DELEGATED DECISION

3.2 Proposed Scheme

The application proposes the construction of a single storey rear extension, hip-to-gable roof conversion and rear box dormer, and conversion of the property from Class C3 (dwellinghouse) to Class C4 (small HMO) for up to six persons. The rear extension would measure 3m in depth, and infill the space to the main rear of the dwelling and side of the existing rear projection.

19188/APP/2024/1794 149 HERLWYN AVENUE RUISLIP

LOCATION AND SITE PLAN

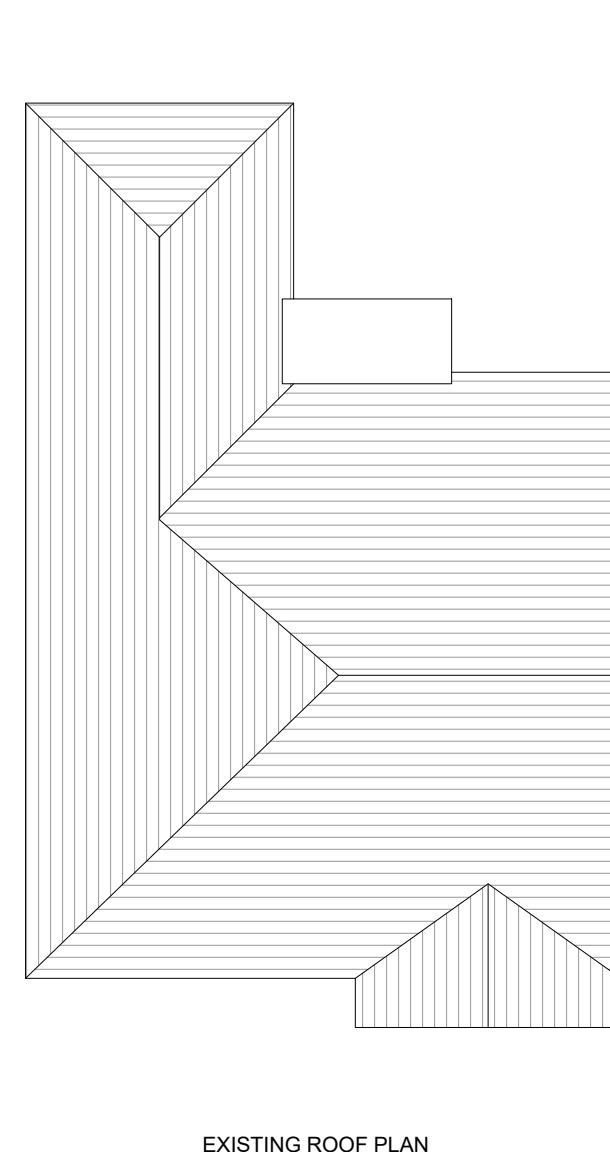
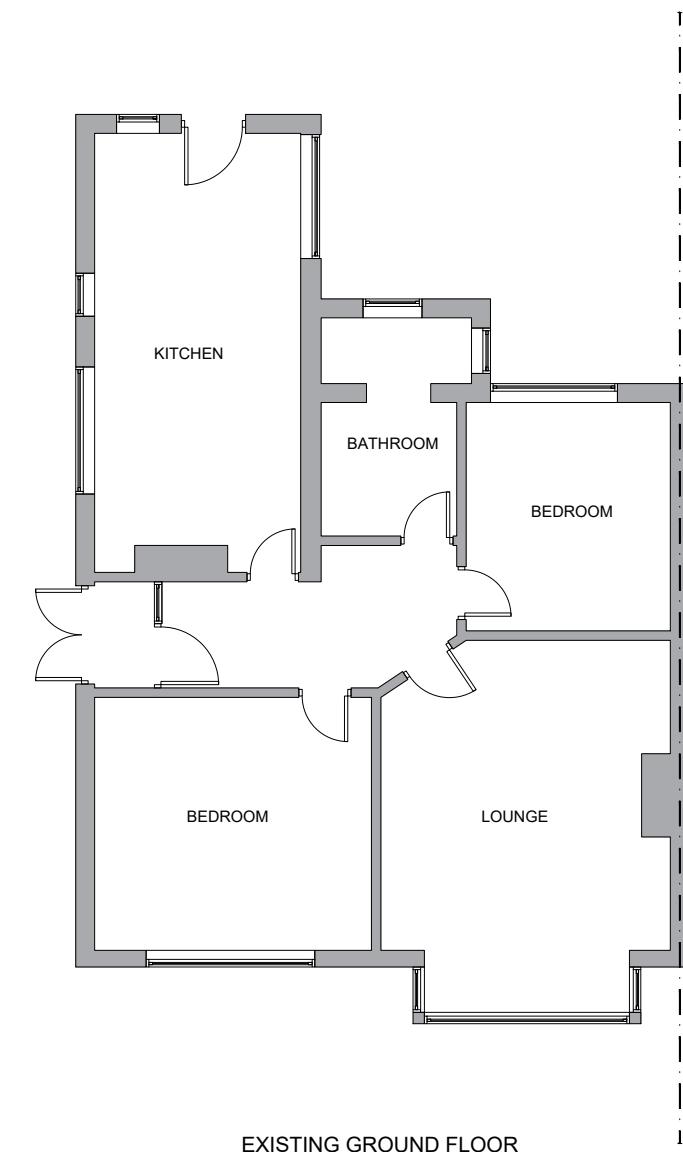
As a residential property, as stated in the London Plan (2021), the existing maximum parking provision for the property would be 1.5 spaces. The proposed change of use to a six-person HMO would therefore in effect double the parking requirement of the property, resulting in a further parking displacement of 1.5 spaces onto the public highway.

The proposal would not comply with the requirements of Policy DMT 6 insofar as the required off-street parking provision would not be met. However, the Policy states that, under certain circumstances, a deviation from the standard may be permitted, but only when it can be sufficiently demonstrated that it would not result in a deleterious impact on the surrounding road network.

In this instance, the applicant has not provided any detail or evidence such as a parking stress survey, transport appraisal or travel plan to dispute this, or to demonstrate whether any spare capacity exists which could satisfactorily accommodate potential parking displacement generated by the proposal without undue detriment to on-street parking capacity and safety on the public highway.

PROPOSED FLOOR PLANS

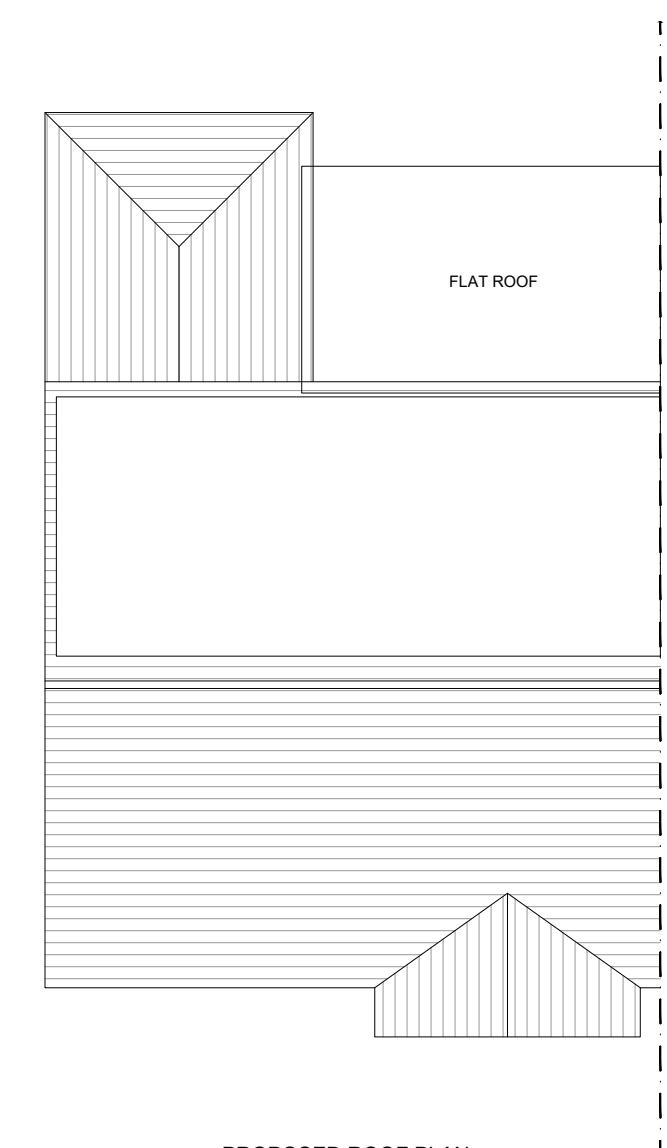
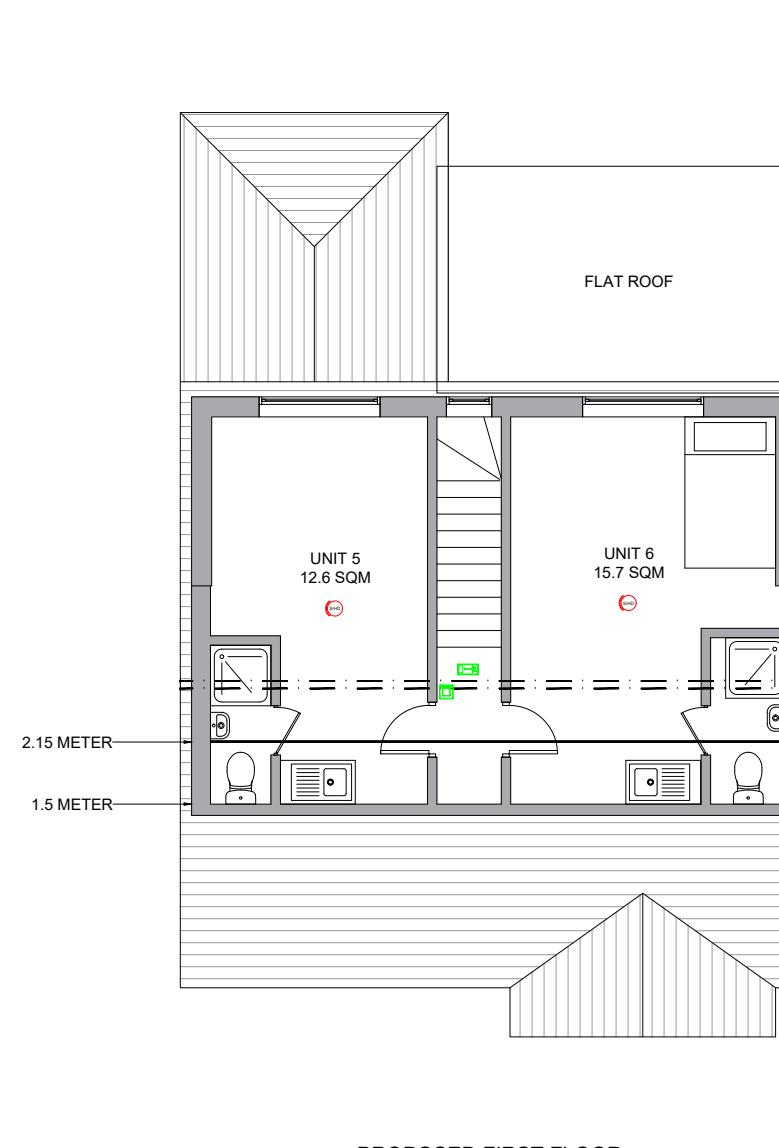
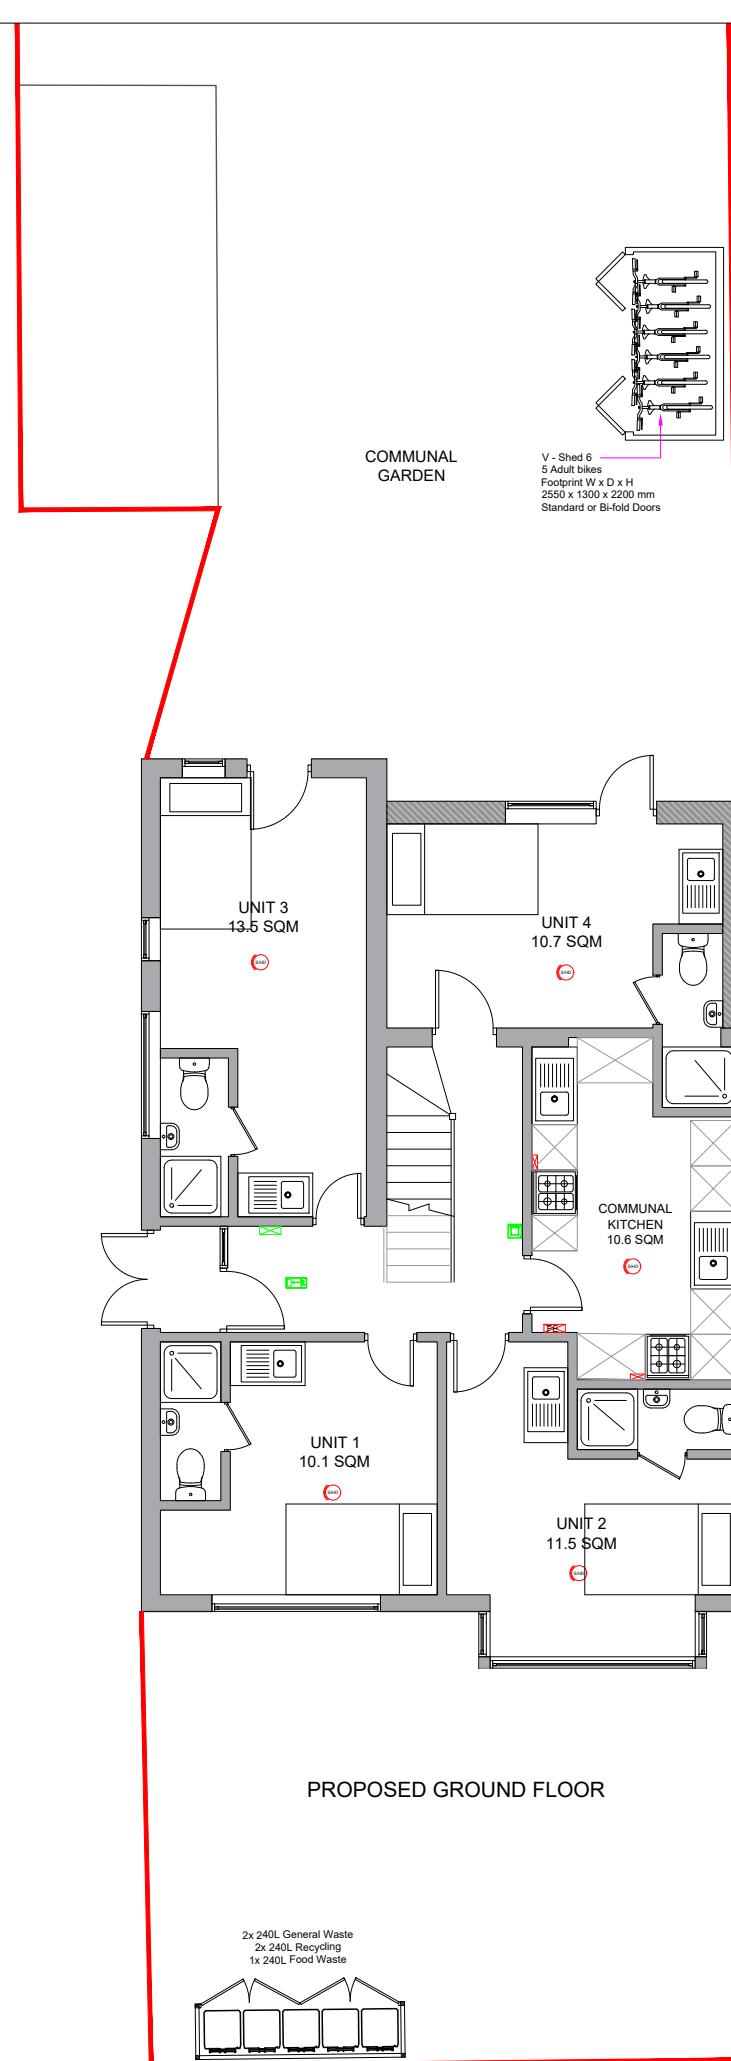
The proposal would create a new internal layout. The submitted plans confirm that each bedroom would have a floor area in excess of 7.5 sqm, would be no less than 2.15m wide, and would be served by adequate means of light and outlook. Notwithstanding this, it is noted that, in terms of

communal facilities, the HMO would only be served by a small (10.6 sqm) and windowless kitchen. Intended to serve six occupants, this room would be cramped and unsuitable for its purpose, particularly as it would likely house both kitchen and laundry facilities, and be used by occupants at similar times. No communal lounge, dining room or other recreational space would be provided to occupants, and the kitchen in and of itself would not provide adequate communal space for residents, nor provide a place for occupants to eat or sit down.

In light of the above, it is considered that the proposed development would provide a sub-standard and unsatisfactory level of internal living accommodation for future occupiers which would be neither comfortable or inviting, nor fit for the intended purpose. As such, the proposal would conflict with Policies D3 and D6 of the London Plan (2021), and Policy DMH 5 of the Local Plan.
